January 26, 2023  
Merrick Project No. 65121260

**Re: Chick-Fil-A/ Extend the Drive-thru  
8110 San Pedro Dr. NE  
DRB Comments  
PR-2019-002213  
SI-2022-02430-SITE PLAN AMENDMENT**

Merrick & Company has reviewed the comments dated January 10, 2023 regarding the Chick-fil-A development. The following summarizes Merrick's responses to the comments provided by the City of Albuquerque Development Review Services.

CONSULTANT PROJECT #: 65121260
 PRINTED FOR: APPROVAL
 DATE: 02/28/2023
 DRAWN BY: KEA
 SHEET: TRAFFIC CIRCULATION LAYOUT
 SHEET NUMBER: C1.1

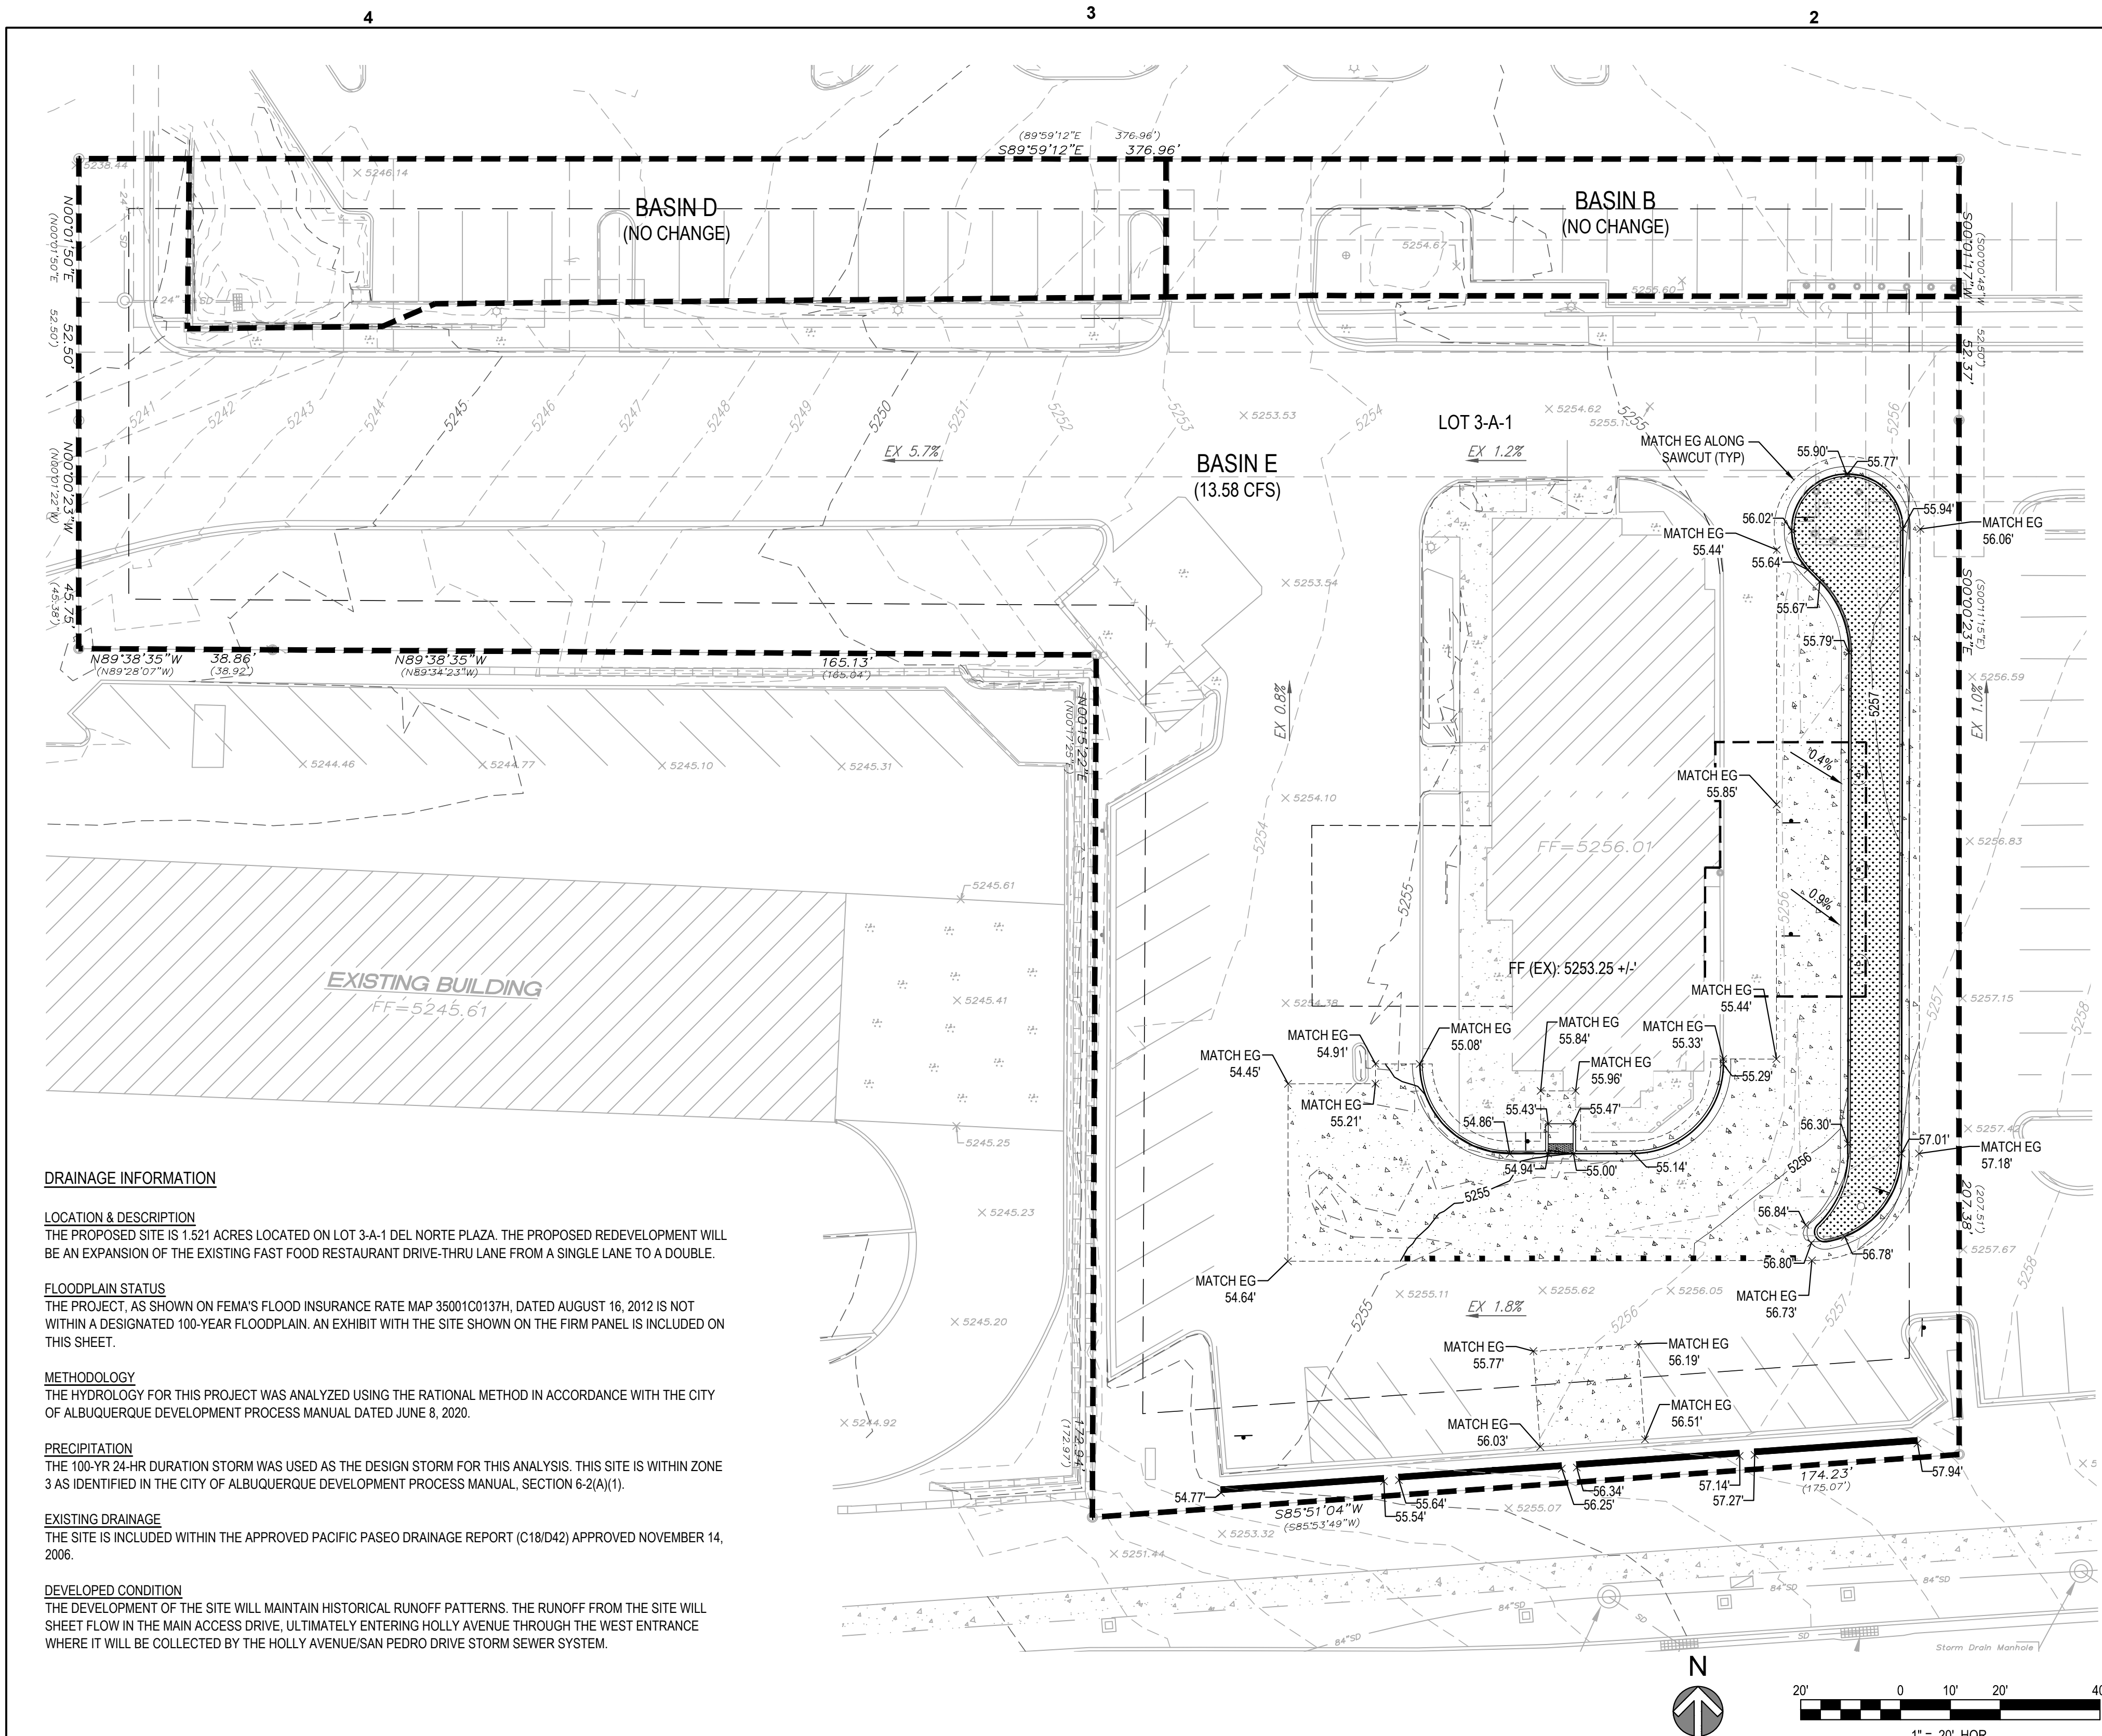
11. Confirm revised parking meets IDO parking requirements. If existing vegetation is being preserved and used for credit against requirements for new vegetation, show vegetation to be preserved on landscape plan

Response: A parking summary table has been provided on the Traffic Circulation Plan exhibiting the development meets the IDO parking requirements. Existing trees and shrub areas added to plans.

PRELIMINARY PLANTING PLAN
1" = 20'

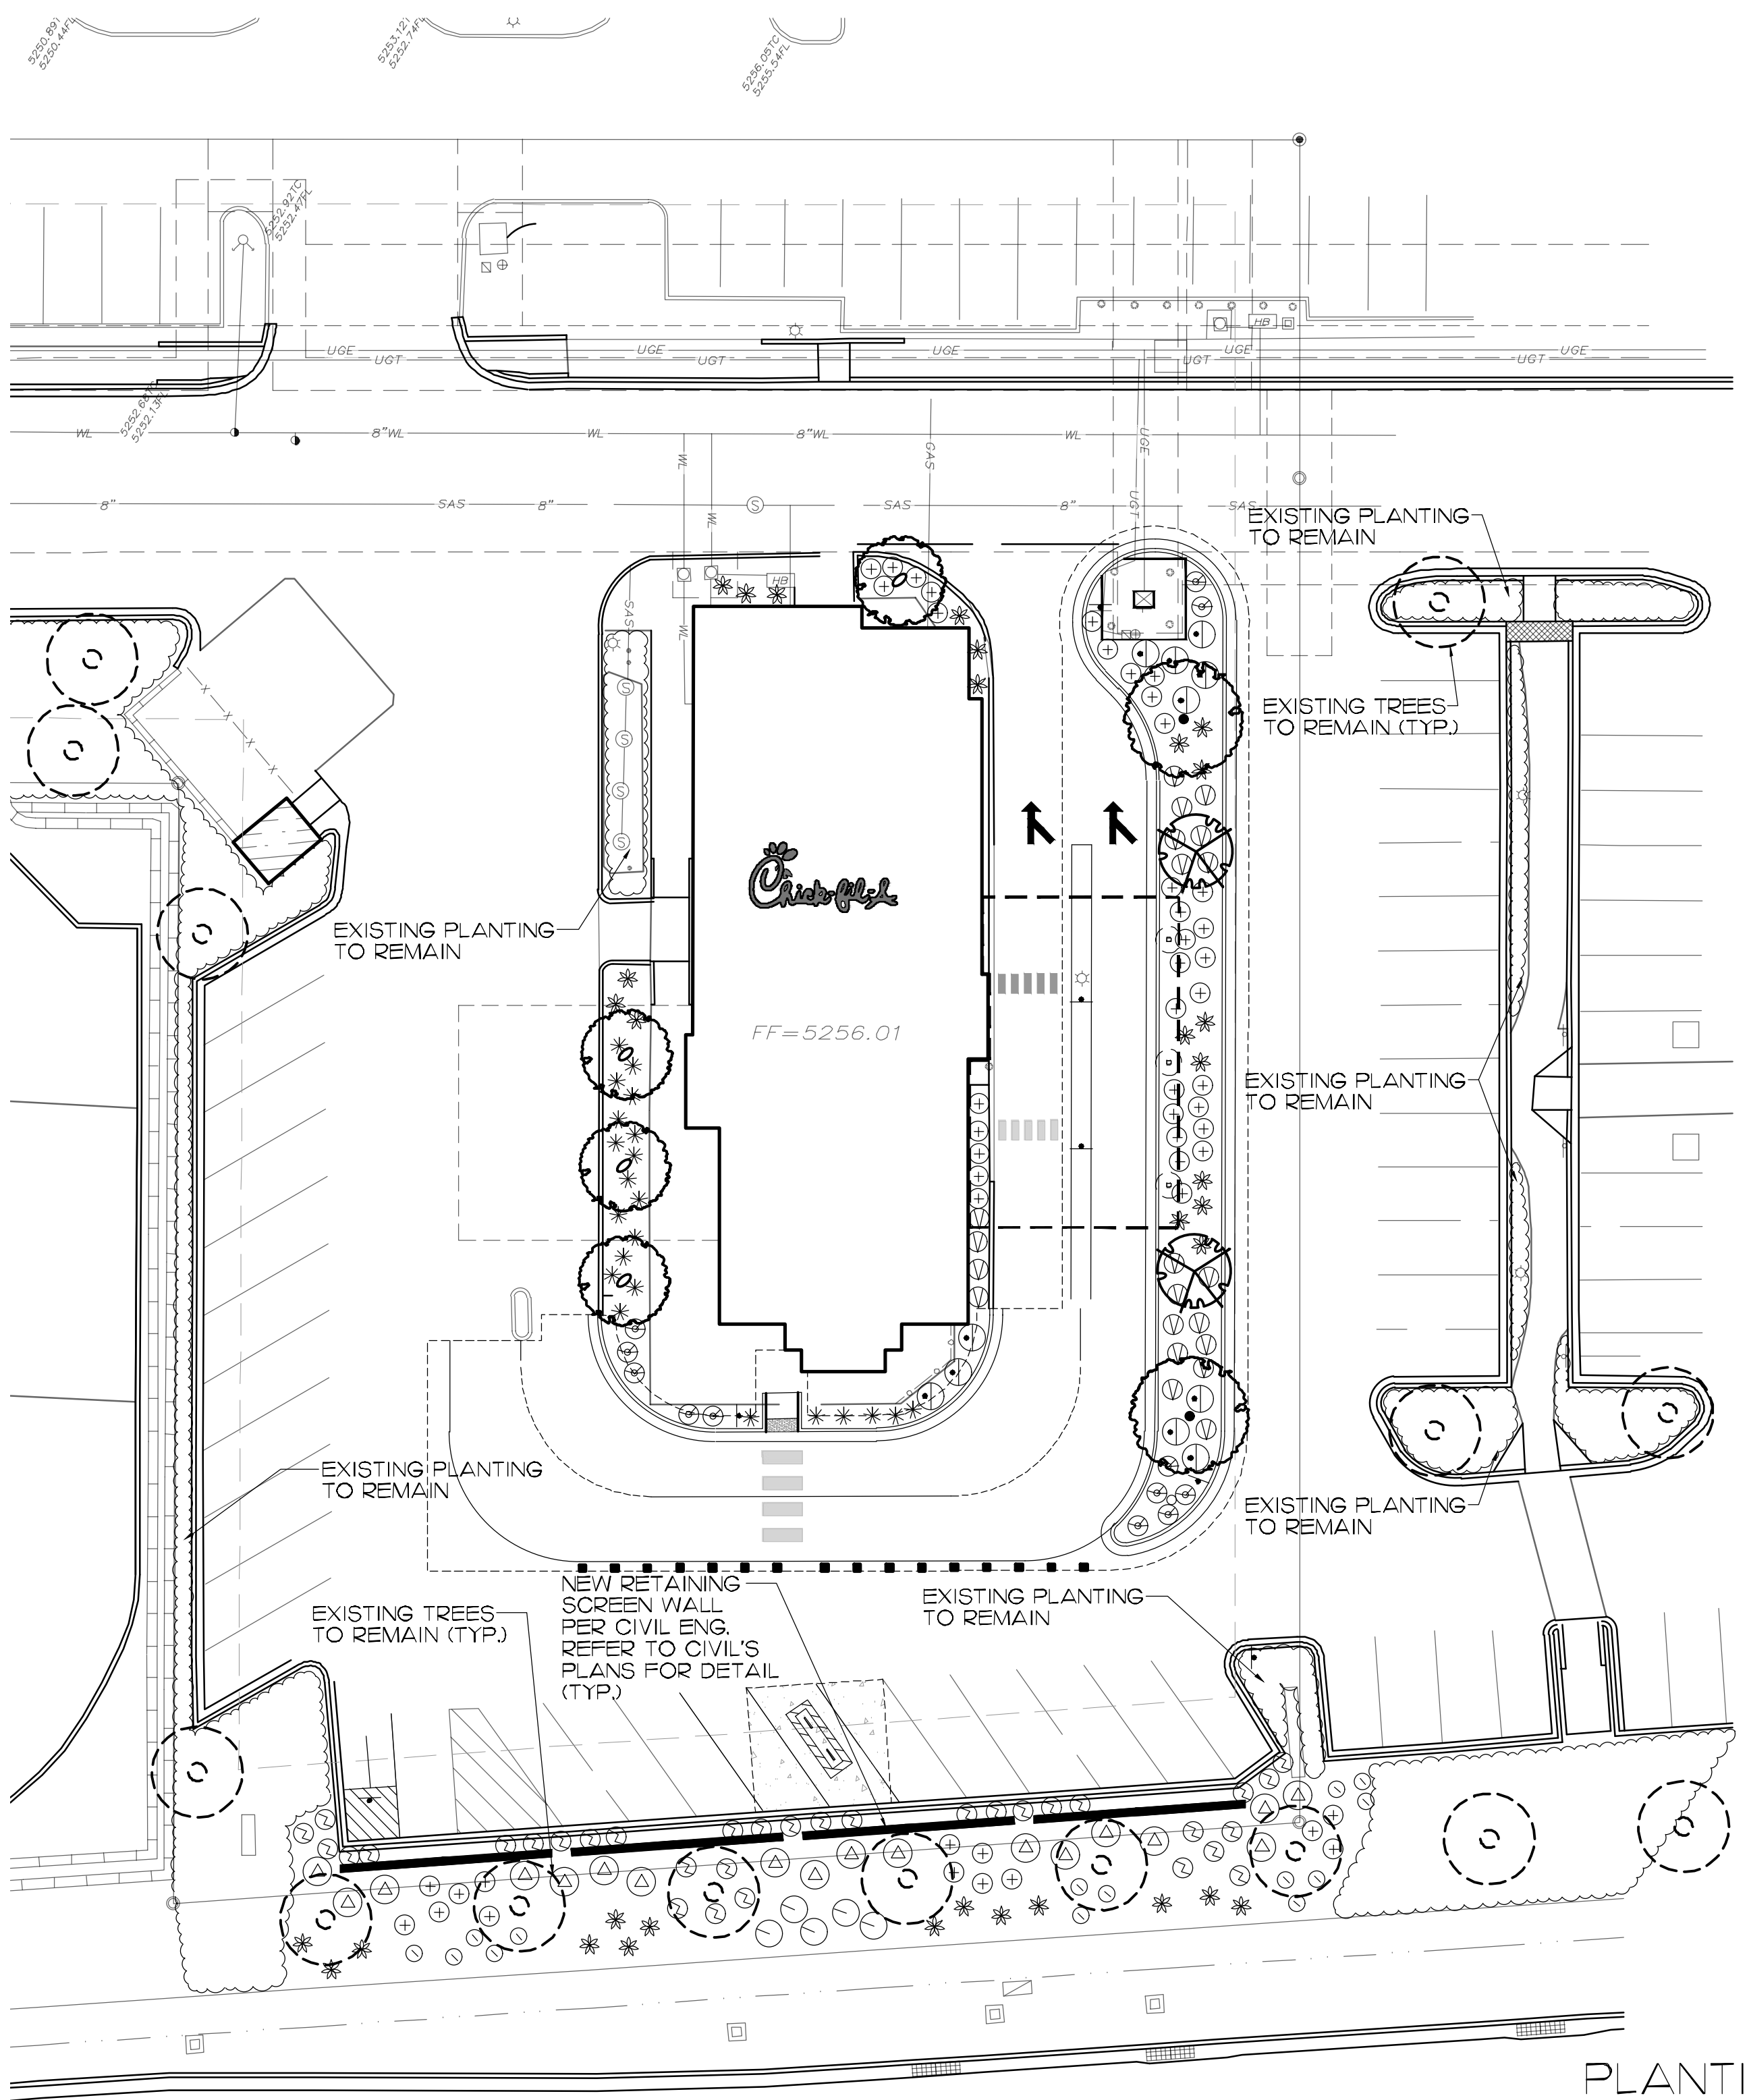
5. Provide landscape calculations on landscape plan – how was 100% landscaped area determined?

6. *Pyrus calleryana* over-used and no longer suitable for commercial applications. Tends to grow vertical, branches break, higher water requirement.

7. *Crataegus phaenopyrum* prefers cooler, wetter locations and it better suited for stormwater basins where harvesting rainwater. Mature size does not meet parking lot tree requirements of 25' min. mature canopy diameter (Washington Hawthorne mature size 20'x20').

8. **See section 5-6(C)(4)(b)** Only trees and shrubs selected from the Official Albuquerque Plant Palette of low water use, drought tolerant, or xeric species and shown on a landscape plan can count toward the requirements of this Subsection 14-16-5-6(C) (General Landscaping Standards), except that, upon presentation of evidence, the relevant decision-making body may authorize alternative species or cultivars that meet all of the following requirements:
- a. Meet the intended purpose of that type of landscaping.
  - b. Are not hazardous.
  - c. Are not identified as invasive on a City or State plant list.
  - d. Are not listed in the City's Weed Identification Handbook.
  - e. Are equally hardy to the New Mexico climate.

9. Clarify length of walkway on west side of building & provide adequate shade trees.

10. **See section 5-6(C)(4)(i)** Shade trees planted approximately 25 feet on-center are required along all required pedestrian walkways. If the walkway is less than 25 feet long, at least one tree is required, or, where there is insufficient space for a tree, a trellis of at least 8 feet high for at least 5 feet along the walkway shall be provided

13. Show on landscape plan existing vegetation to be protected during construction.

14. **section 5-6(C)(12)(b)** All existing vegetation preserved and used for credit against the requirements for new vegetation shall be protected during construction by a fence erected one foot beyond the drip line of the vegetation.

17. It is recommended to increase density of shrubs to buffer parking

18. Please identify mulch (gravel?) and add note regarding organic mulch around trees per IDO section 5-6(C)(5)(e) below:

21. Confirm if existing landscaping on southwest side of lot are remaining – they are shown in prior approved Landscape Plan, but not shown in this landscape plan.

22. As per Planning comments, show landscaping calculations as to requirements and how they are being met.

29. A five-foot clear area around ground-mounted transformers, with ten feet clearance for any side with doors, is required for safe access by PNM maintenance and service crews. Please ensure that both the site plan and landscape plan reflect these requirements.

Response: Landscape calculations added/revised.

Response: Replaced as requested.

Response: Replaced as requested.

Response: Species modified as requested.

Response: A dimension has been provided along the entire length of walkway along the west side of the building. Trees added as requested.

Response: Trees added as requested.

Response: Shown as requested.

Response: Note added as requested.

Response: density of shrubs has been increased.

Response: Notes revised to gravel/rock. Note is also at the bottom of the planting legend.  
Notes added as requested.

Response: The existing landscaping on the southwest side of lot are to remain.

Response: Landscape calculation added/revised

Response: Noted, landscaping has been revised to ensure these requirements are being met.
